DESIGN STATEMENT BY THE CONSULTANT

PROJECT: Trinity Grammar School Renewal Project
Prospect Road, Summer Hill, NSW, 2130

Arcadia is responding specifically to comments No. 12 & 13 from the Independent Planning Commission (IPC) for Trinity Grammar School Redevelopment SSD/10371 issued 16/08/2021 by Department of Planning, Industry & Environment

Section I-I

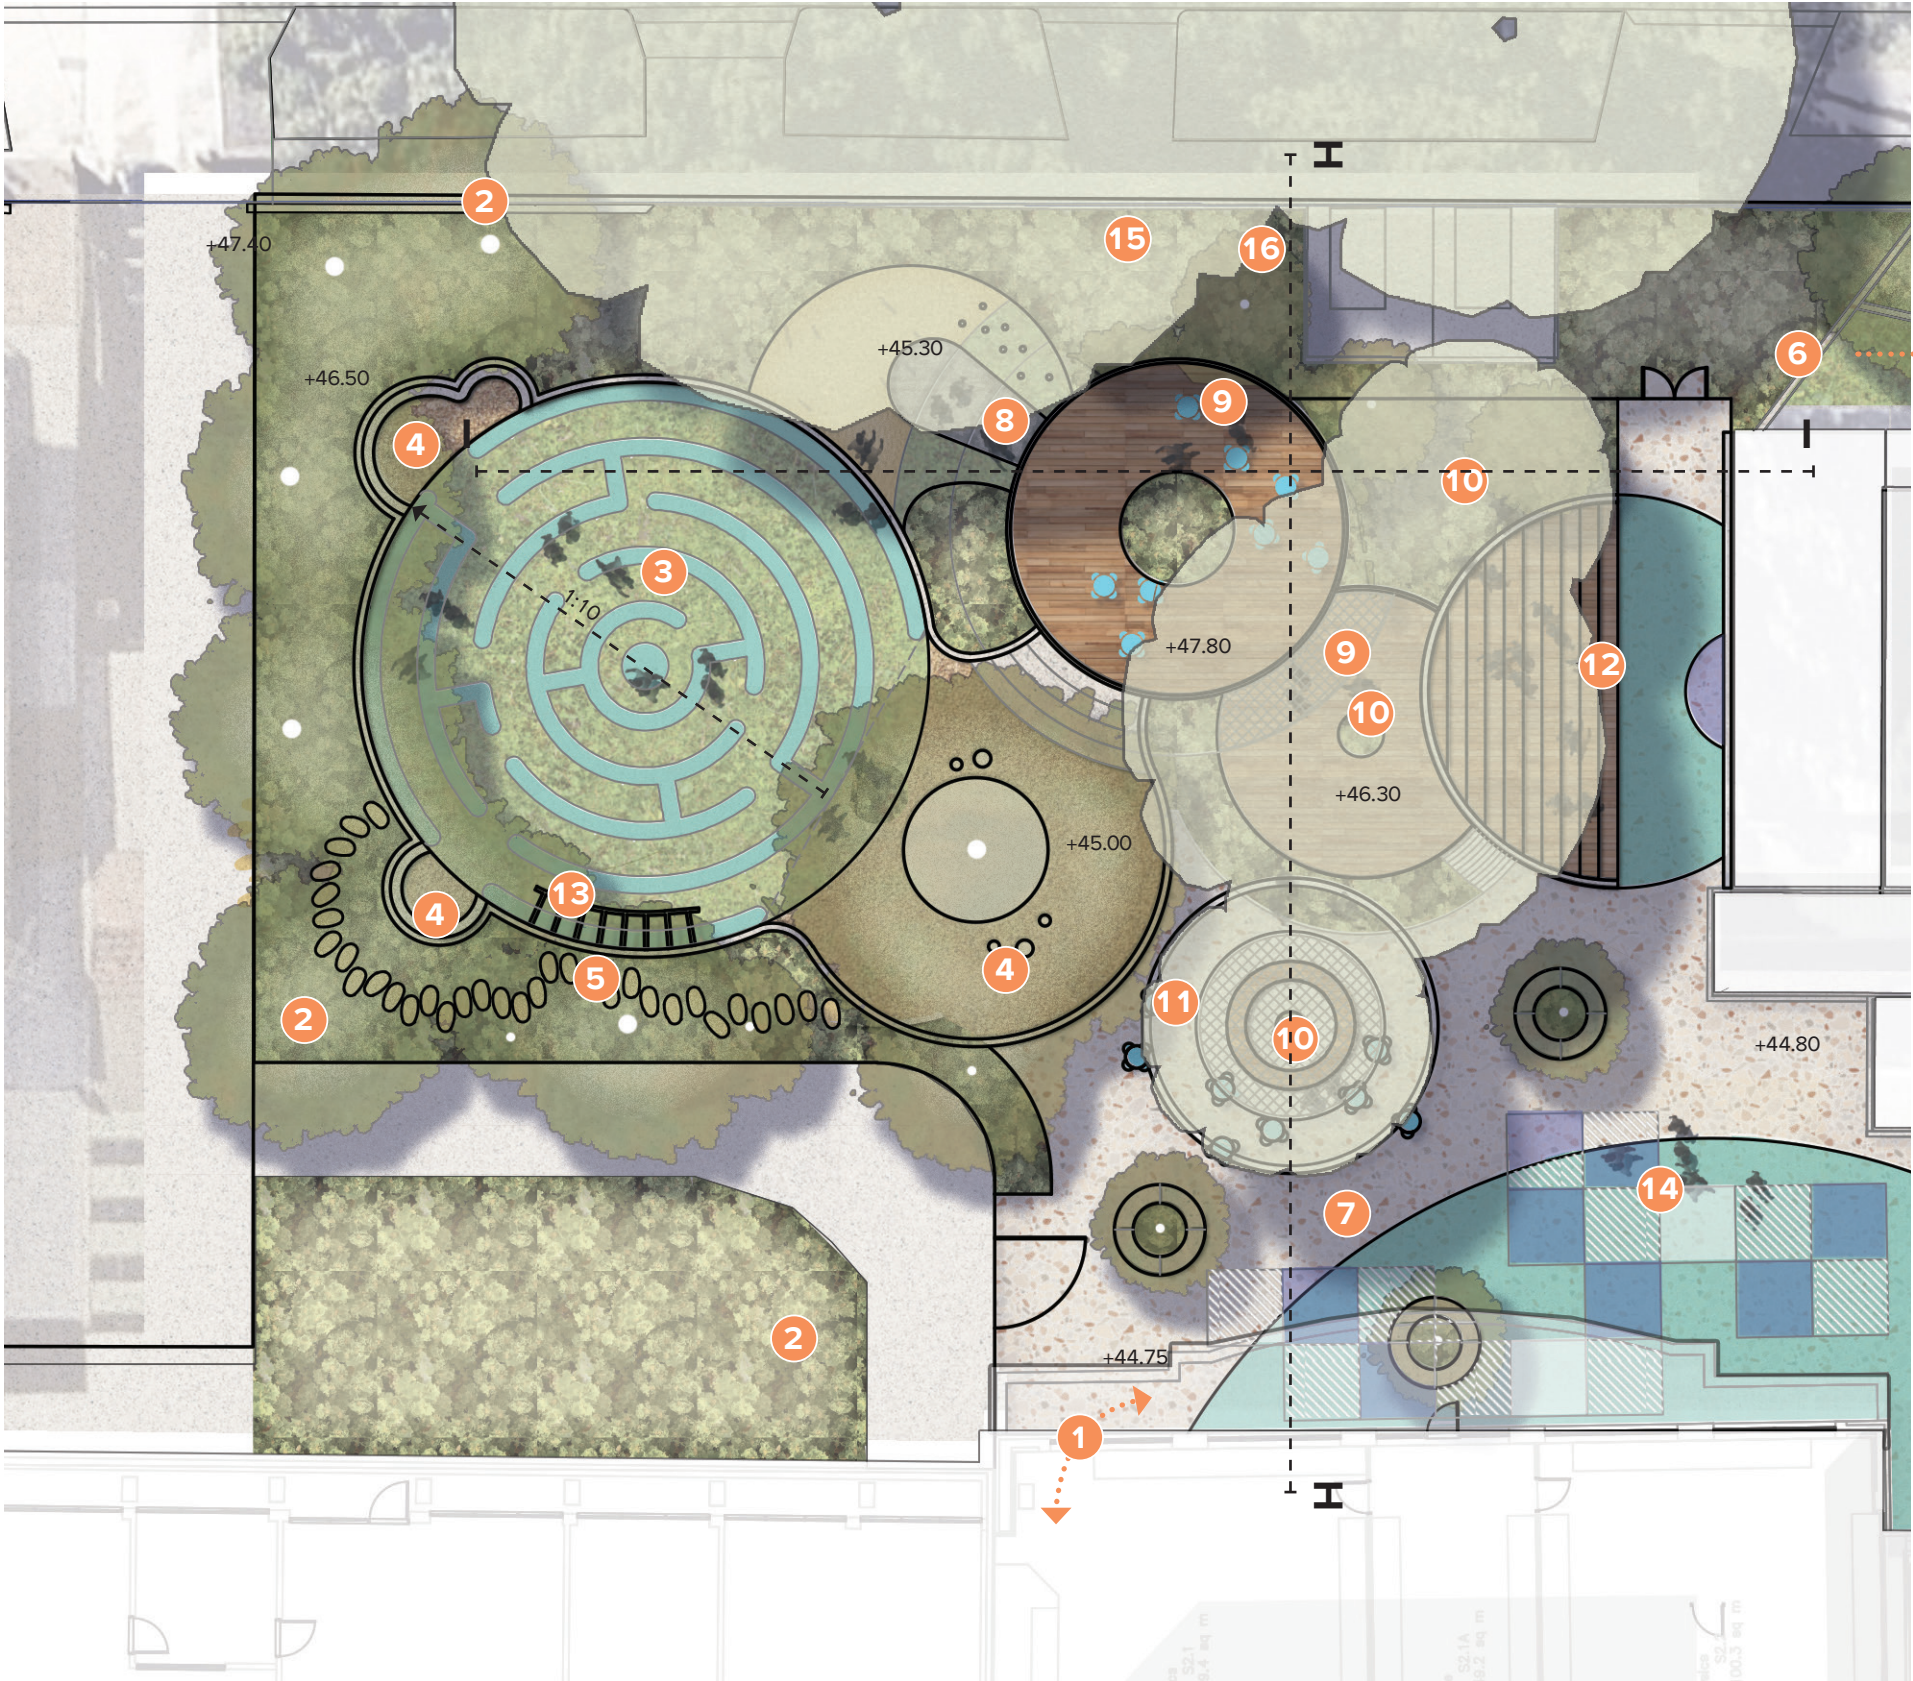
12: Explanation of Section I-I on Junior School Play area (landscape drawings).

The perimeter planting species to the Junior School are *Acmena smithii* – Lilly Pilly, which will reach a mature height of up to 5m creating a continuous hedge for softscape privacy from Seaview St. The hedge species is commonly used as a screening species and given its northern aspect and beneath existing Fig Trees, the robust character of the Lilly Pilly will thrive in a range of microclimates from heavy shade to full sun.

The Section I-I illustrates the design intent for the play space and the area extents from the building entry to the perimeter fence, to illustrate this the plants opacity is transparent for graphic communication purposes. The Play space is designed to cater to safety and privacy requirements, with set back from the fence and appropriate fall zones and exclusion zones to influence the final design during the design development stage.
